THE ABLE MARINE ENERGY PARK DEVELOPMENT CONSENT ORDER

TR030001

**Responses of the Harbour Master, Humber
to ExA's second round of written questions**

Unique Reference Number	URN10015524
Rule No.	8 (1)(b)
Document Ref.	ExAQ02
Author	Harbour Master, Humber
Date	04 September 2012
Date of revision & version number	07 September 2012 (Revision 1.1)

Drawing file: published-documents / TR030001-000301-Indicative Sequence Plan View 3 of 3.pdf

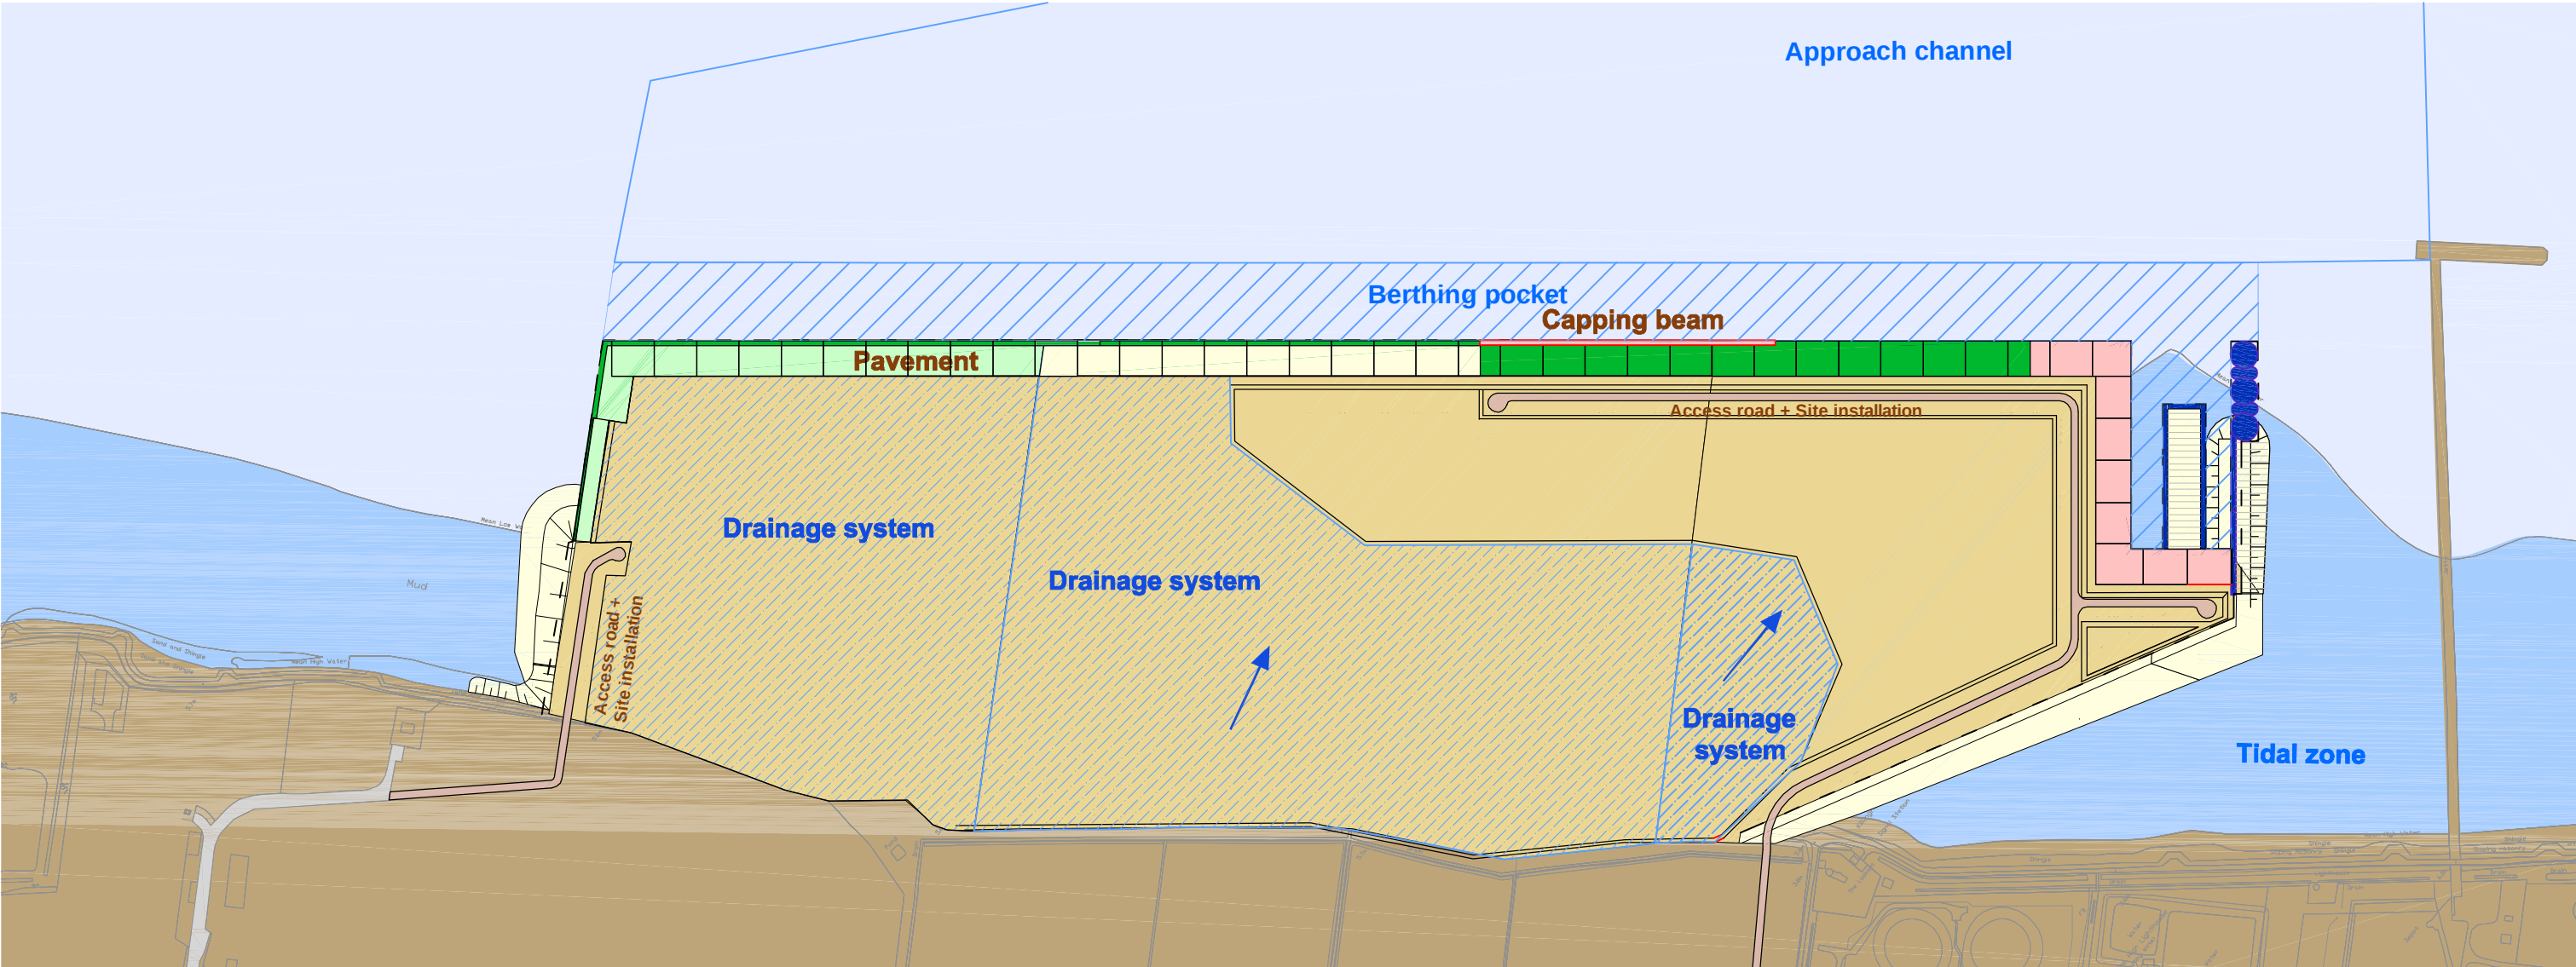
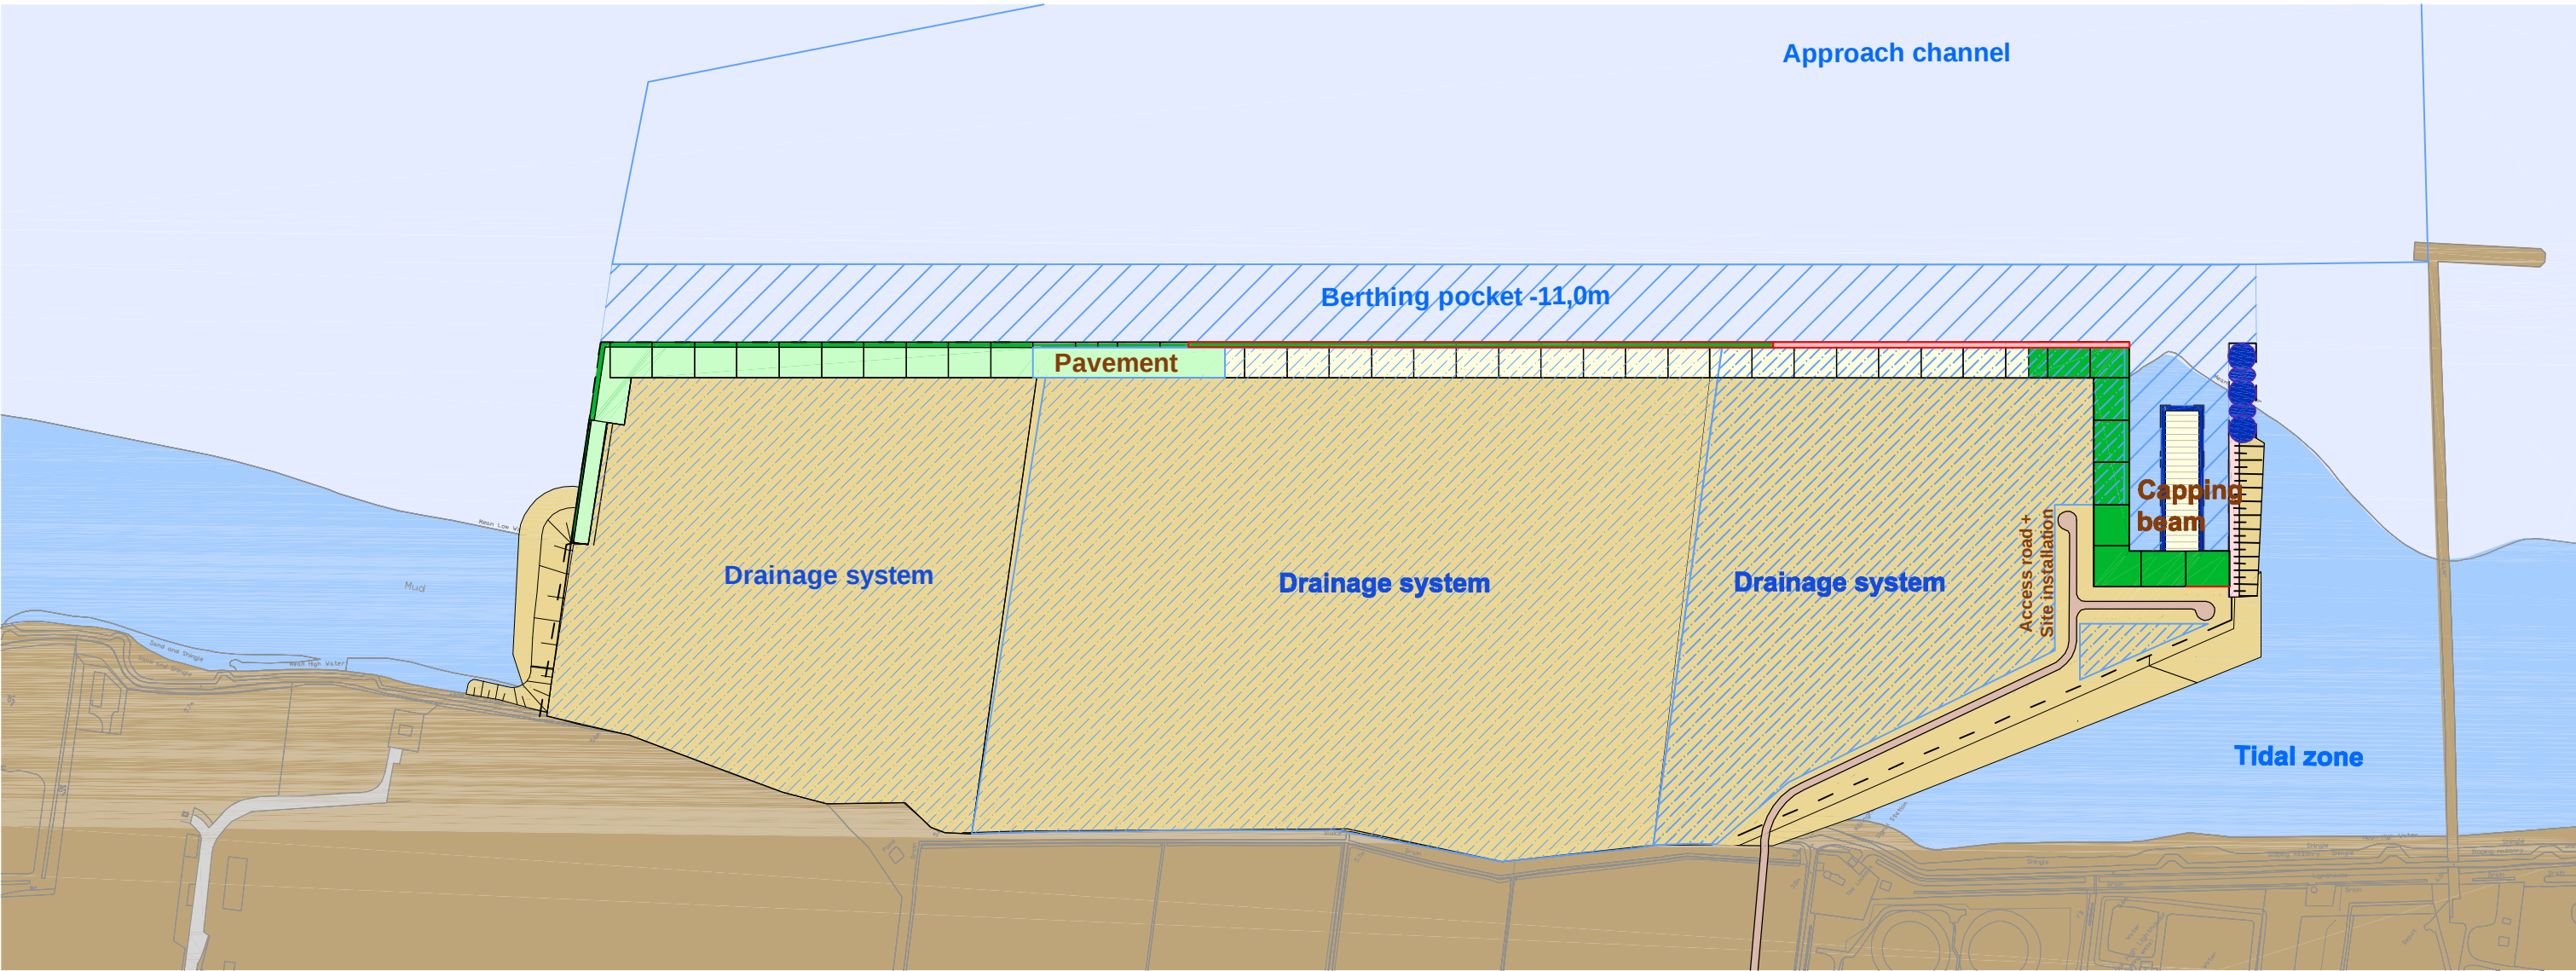
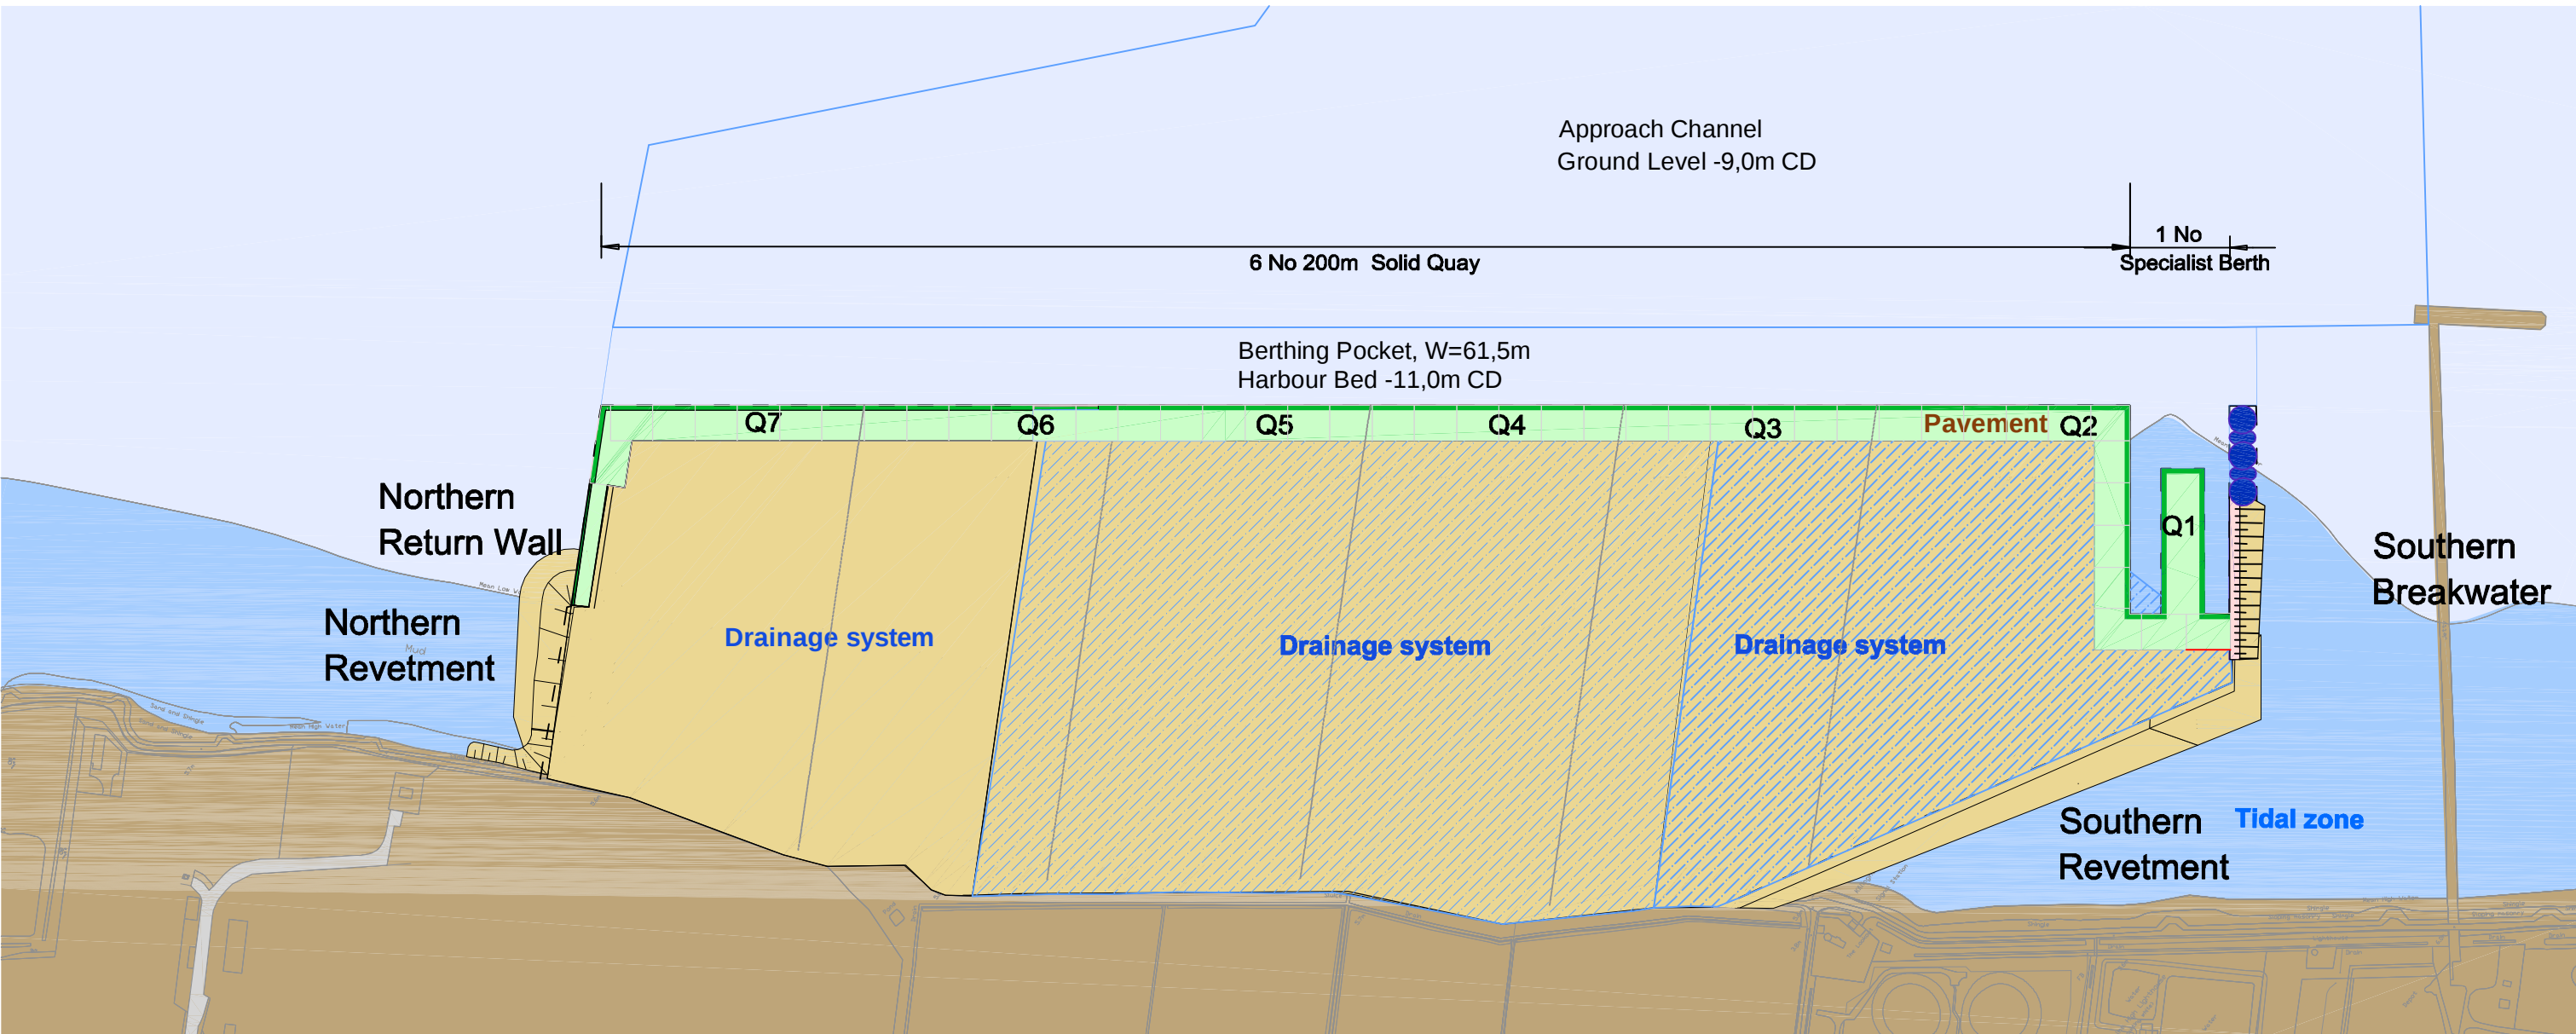
4. The original ES states that, in places within the 61.5 metre wide berthing pocket, Able intends to dredge down to hard material to a maximum of -14.5m and will then backfill to -11.0m using rock dressed with gravel so that jack-up rigs¹ have a "hard-standing" on which to jack-up. The Harbour Master, Humber is unsure whether the smaller gauge "dressing" material of this description will necessarily stay in place within the berth pocket and the SEI does not have any information in this regard.

Any migration of backfill can be expected to cause siltation. Able has indicated to the Harbour Master, Humber that, as an addition to the SEI, it will commission an engineering report to verify the requisite material size to prevent dispersal of the dressing material from the berth pocket. The Harbour Master, Humber seeks an assurance from Able that it will do so.
